Parks and Wildlife

August 8, 2018

Re: Cascade Metropolitan District Water System Improvements (Cascade Creek and Fountain Creek Crossing)

EROSION CONTROL PLAN- SEGMENT 8a & NOTES
WATER SYSTEM IMPROVEMENTS
CASCADE METROPOLITAN DISTRICT NO. 1

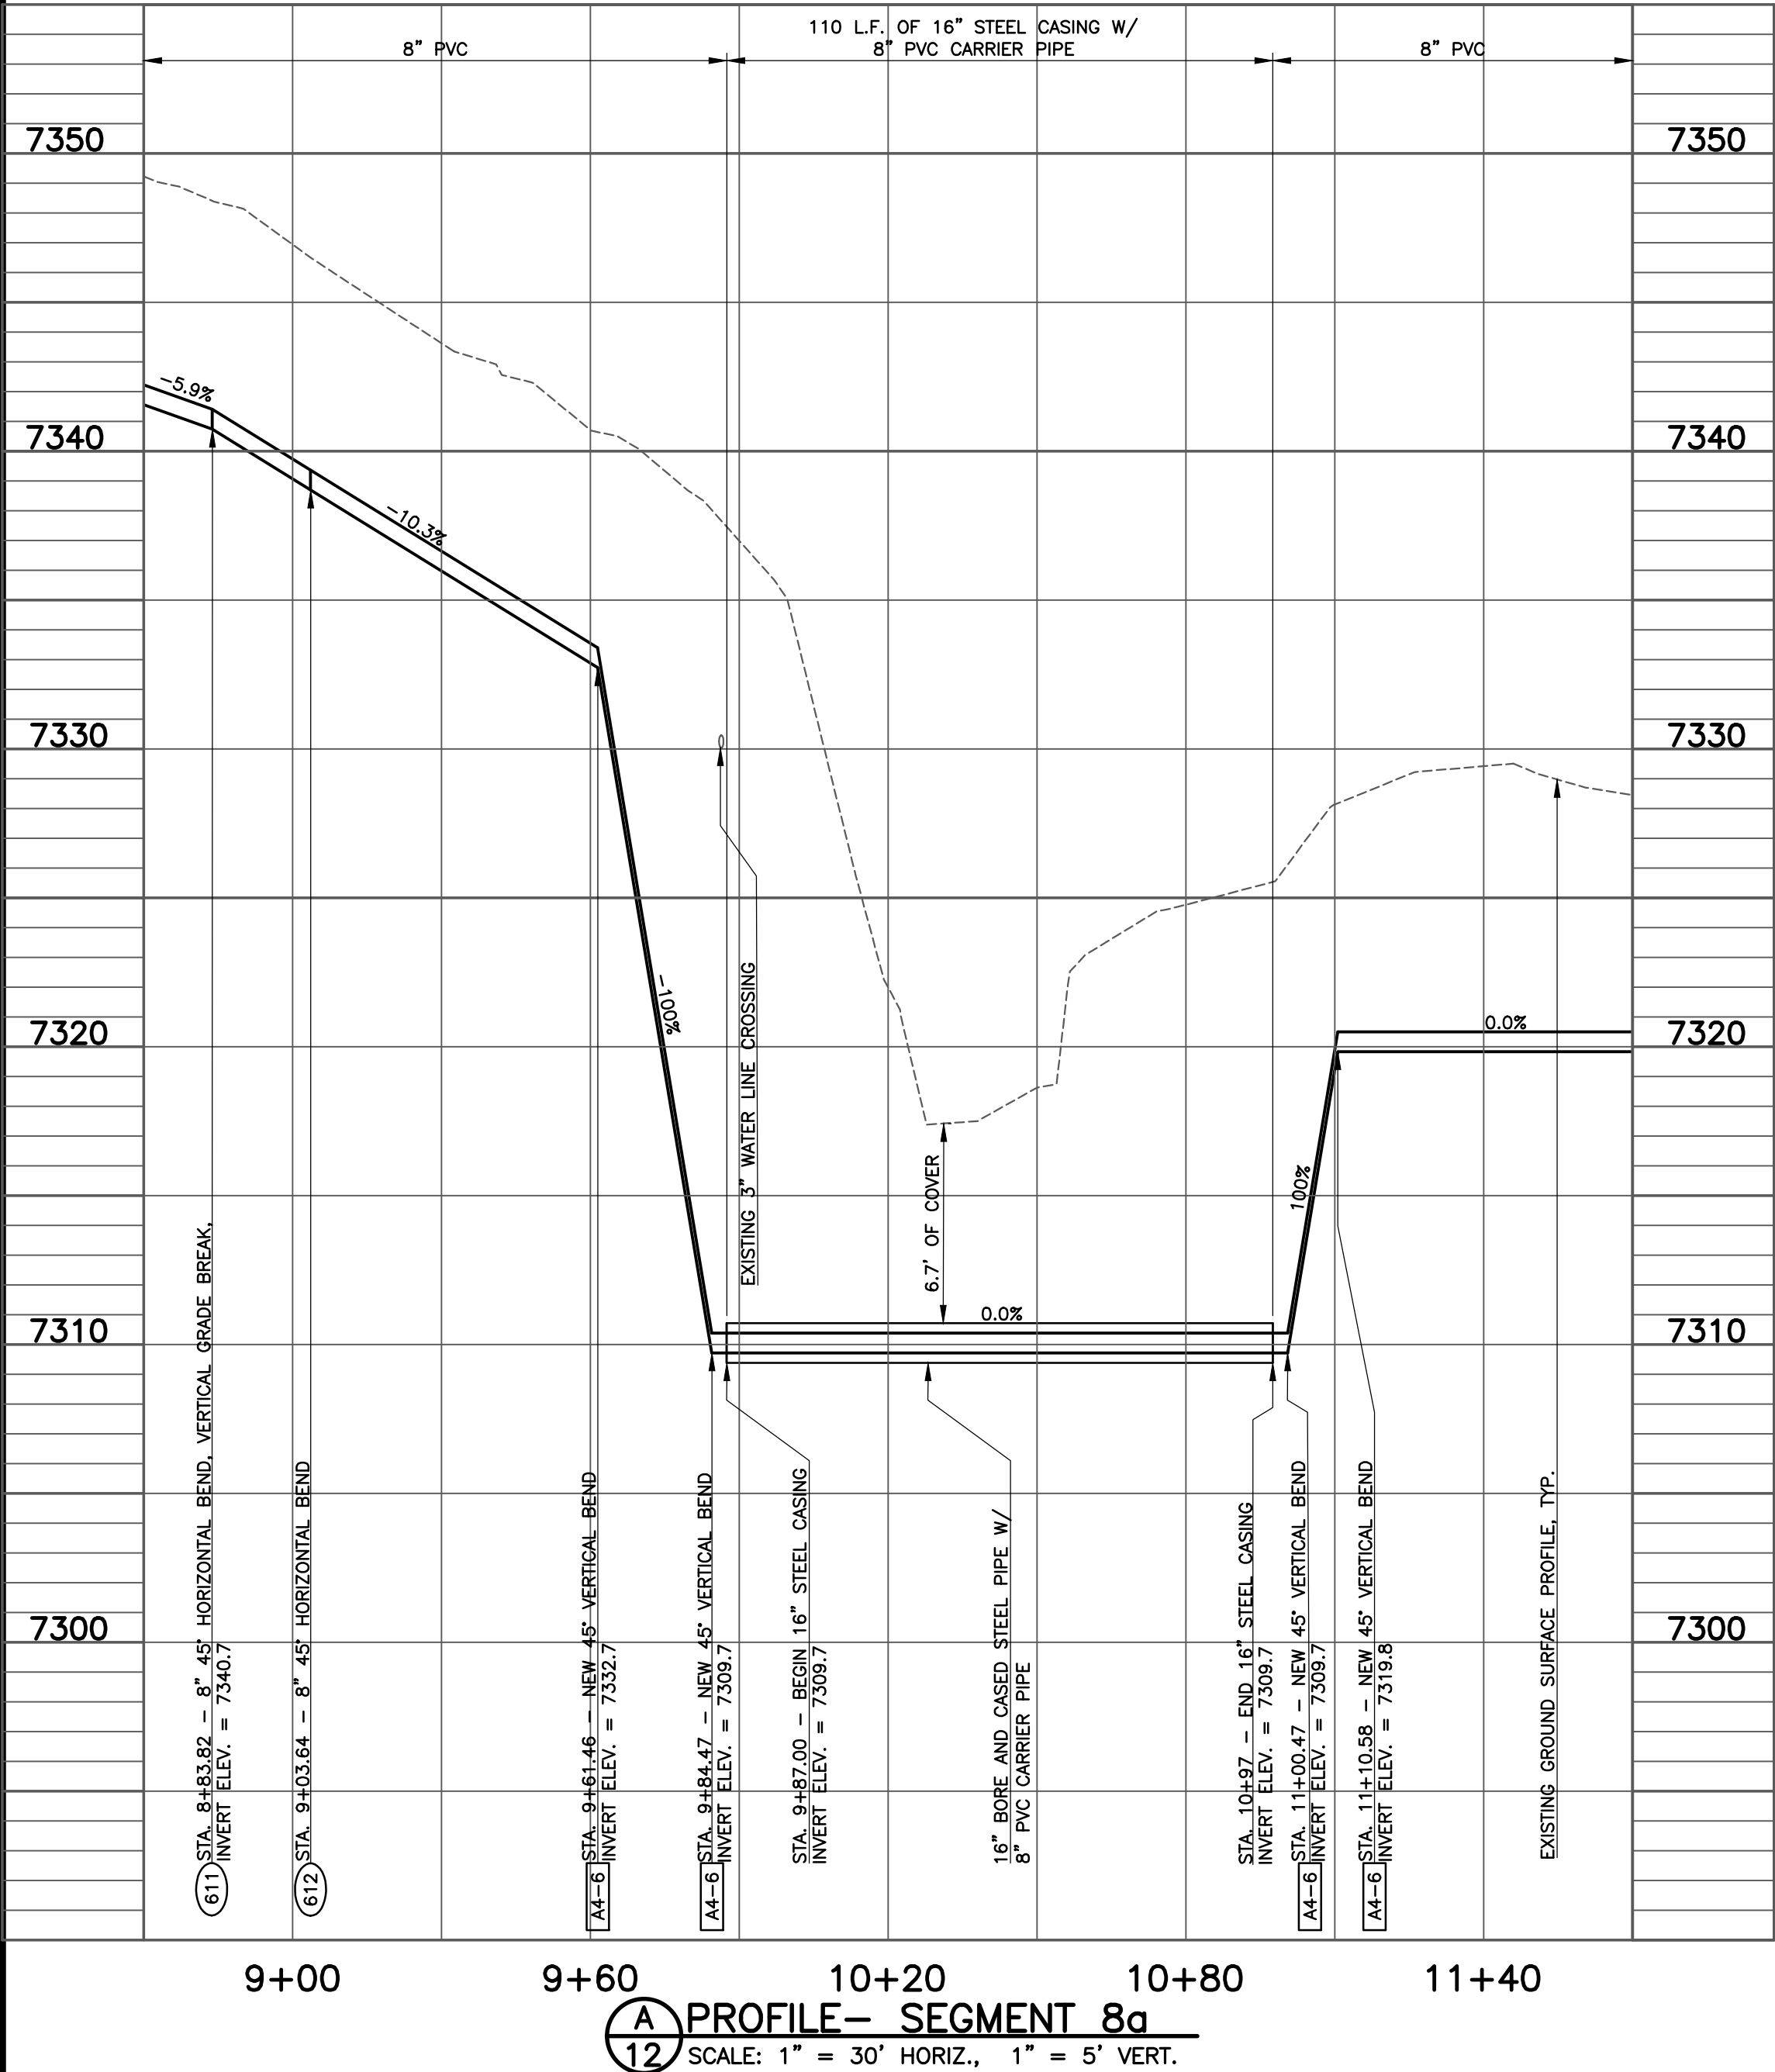
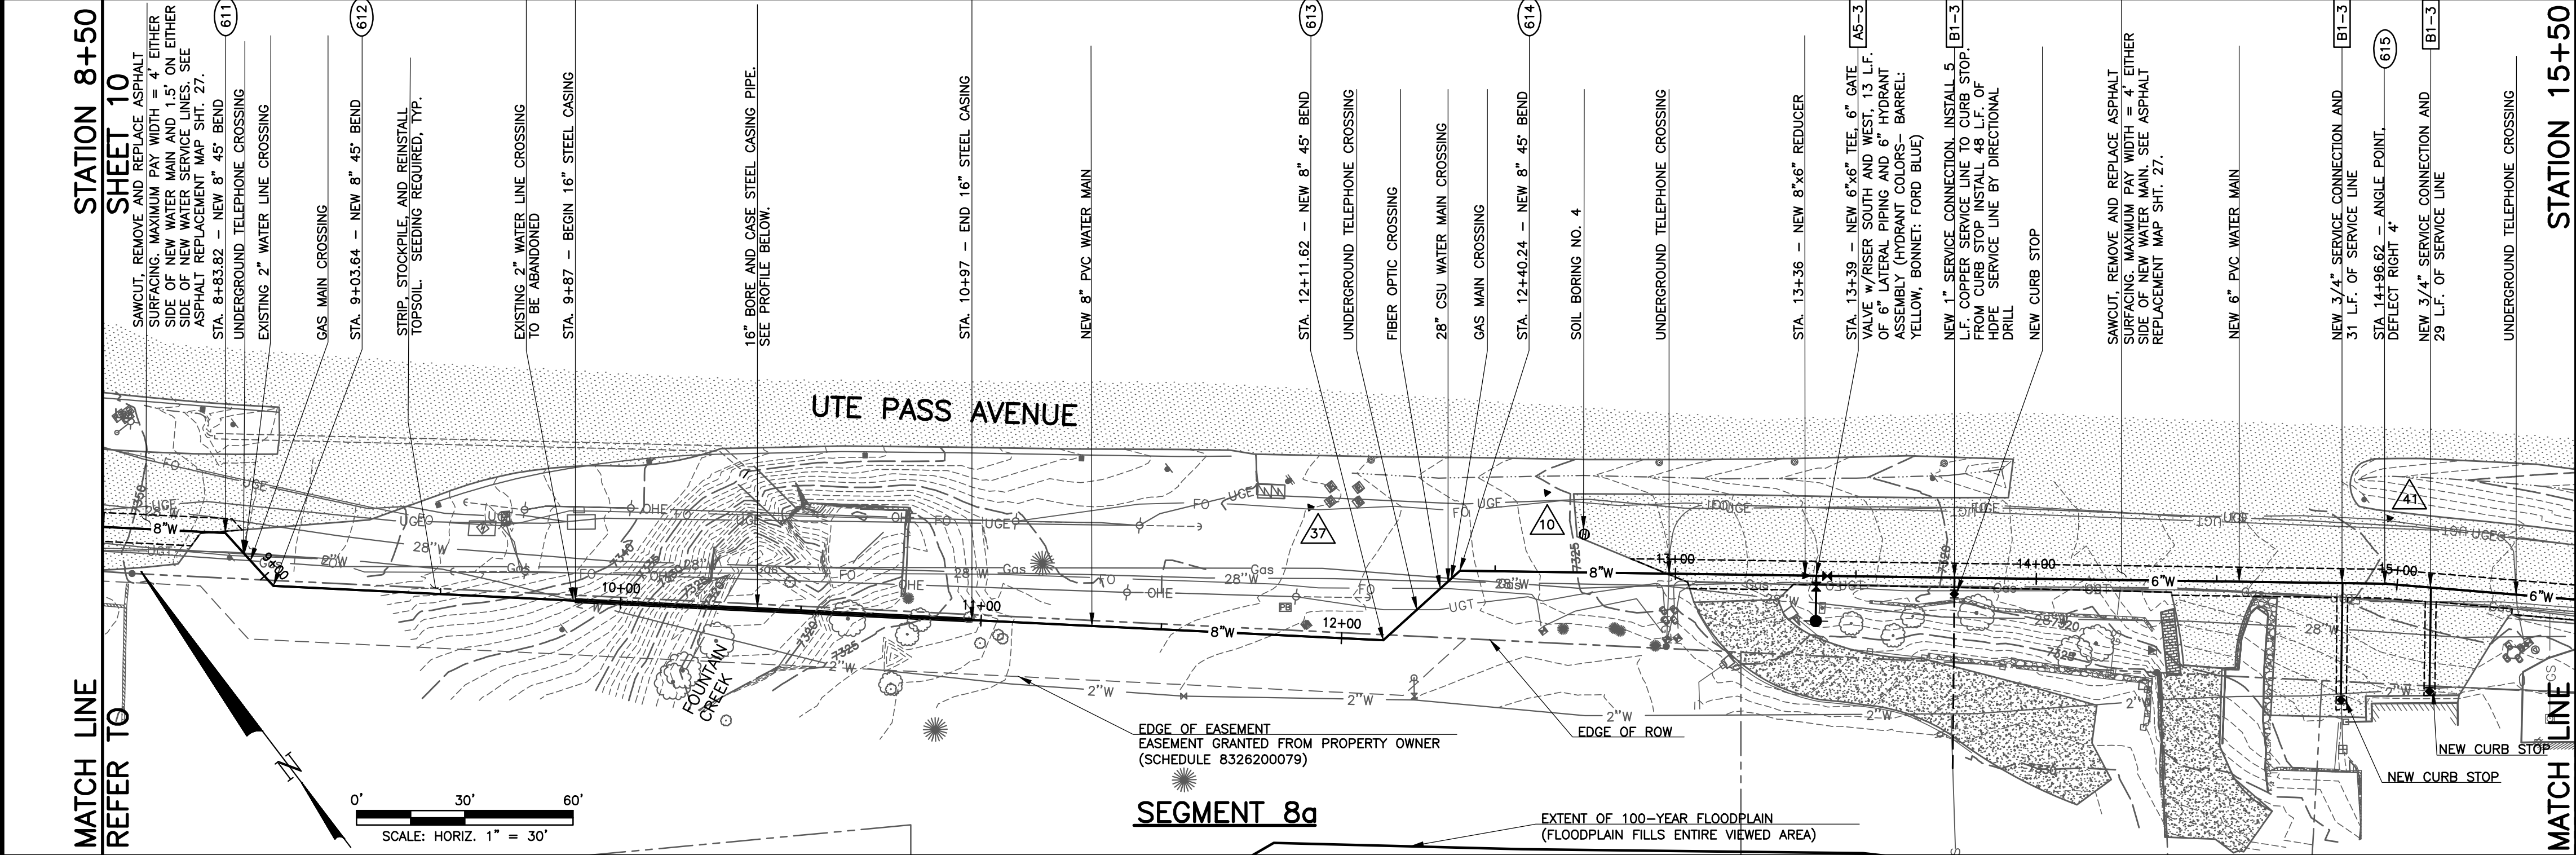
The project should as much as possible, minimize ground disturbance and disturbance of the stream bed. Any work that dewateres or diverts the natural flow of the river should be completed as quickly as possible. Any fish seen trapped because of construction should be relocated to flowing water downstream of the construction area.

Removal or disturbance of woody riparian vegetation should be minimized as much as possible and any areas where woody vegetation is removed should be replanted with native woody vegetation. All stream bed and banks excavated during the project should have the same or similar sized material used to refill to the original grade.

All Sediment control BMP's specified in Federal and State discharge permits should be in place at all times. Concrete can contaminate streams and directly kill fish, washouts should be used for all cleaning of concrete equipment.
